R/93/20/HH & R/94/20/L

Listed building consent for the demolition & erection of conservatory.

Martyn White
Principal Conservation Officer, Planning Ser

Drawing: Proposed Elevations, Plans and Roof Plan

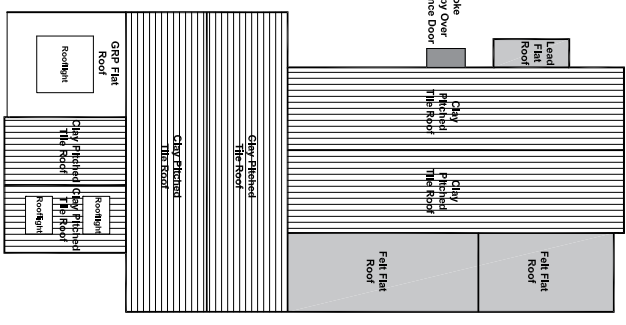
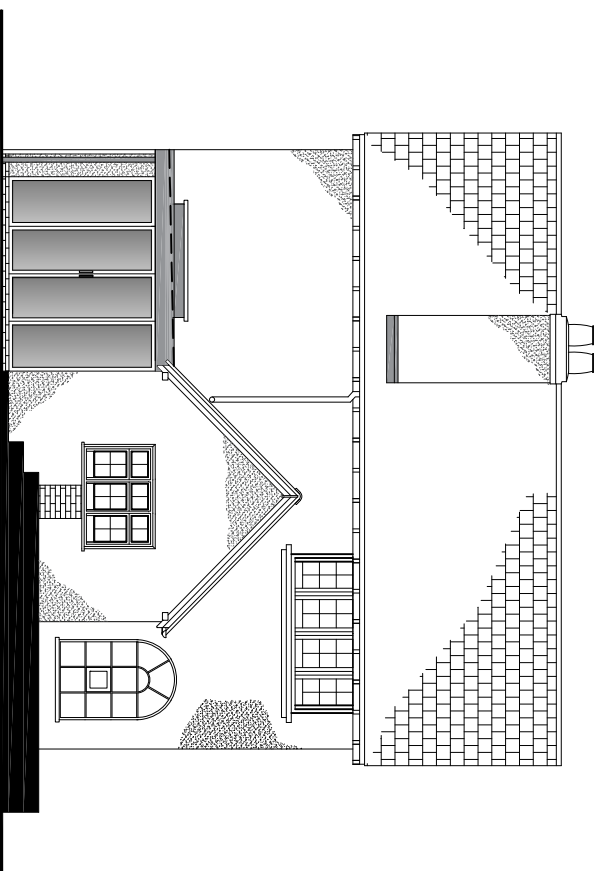
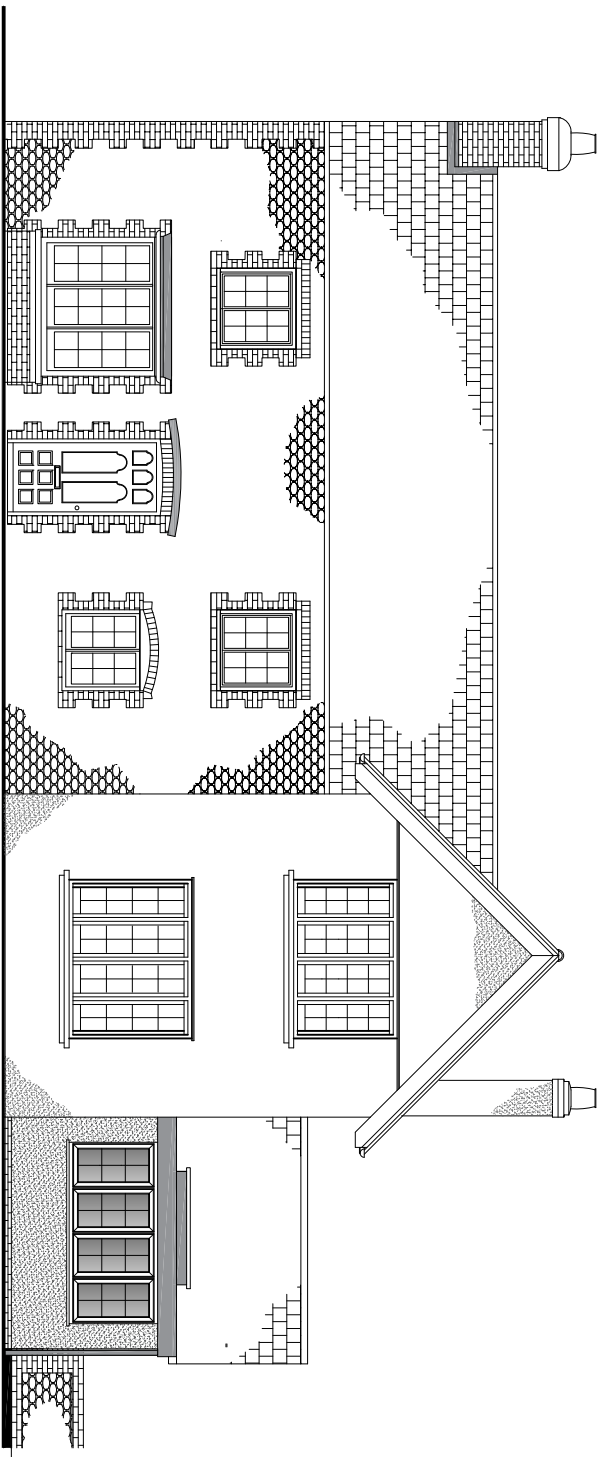
The proposal is for the demolition of an existing conservatory and for its replacement with a small, single storey extension with rooflight. The existing conservatory is not appropriate for the listed cottage and its removal will have a positive impact. Further, it is considered that the proposed design appears to be suitable for the host building, being simple in appearance. Of note is the fact that the East elevation (front) windows will match the design of the existing building, and that the existing flint and brick base wall will be used as part of the proposal. Traditional materials for the windows are preferred, but details can be provided for by way of condition, if you are minded to approve the applications.

The rooflights on the 1910 extension should be of conservation standard; flush mounted with a vertical glazing bar.
